**A14 Cambridge to Huntingdon improvement Scheme;
Interested Party no 10030913**

Comments on:

**STATION CAR PARK ACCESS
WORK NO. 36 - WORKS PLANS
SHEET NO. 29**

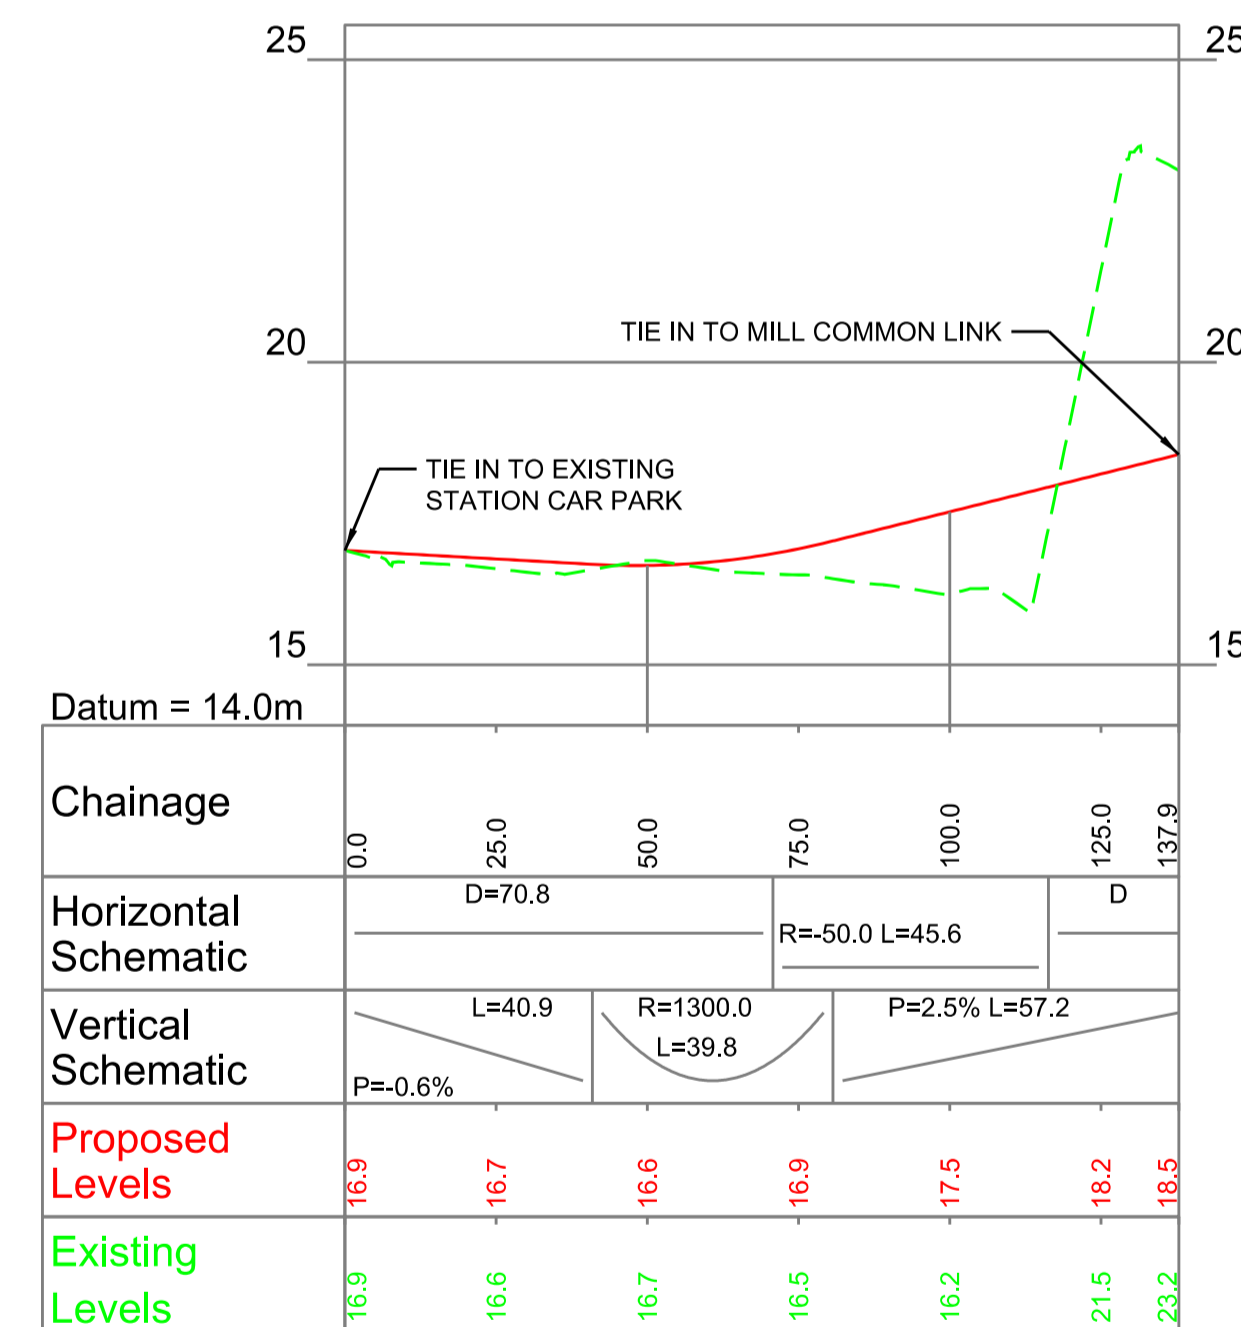
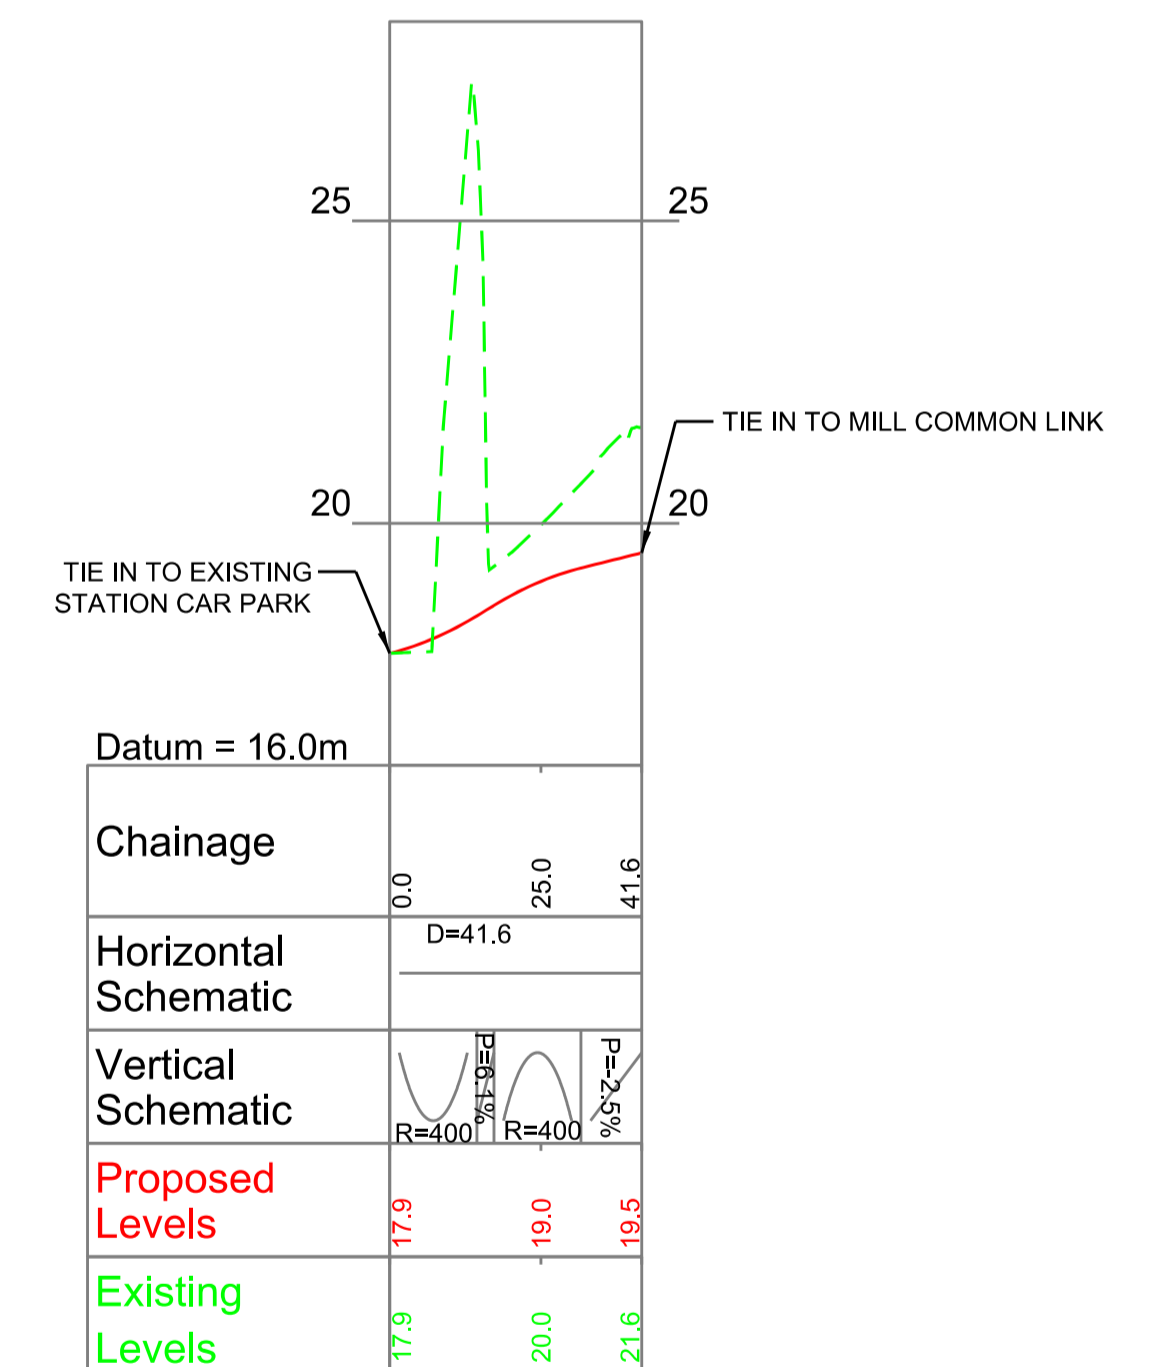
We endorse the Council's view that changes to car parking, drop off facilities and the public transport interchange and the impact of the proposed new station access roads need to be considered at this stage rather than as matters to be agreed later as part of 'accommodation works'. Current proposals will result in a loss of car parking and the public transport interchange to the east of Huntingdon railway station. The future requirements for parking on all three parking areas serving the station should be considered now since they will have a significant impact on the local road network in west Huntingdon.

We agree with the Council that properties affected by noise, vibration and quality issues should be properly highlighted. This list should include properties in Station Cottages, Huntingdon which are likely to be affected by excessive noise and fumes from stationary or slow moving traffic on the proposed new station access road.
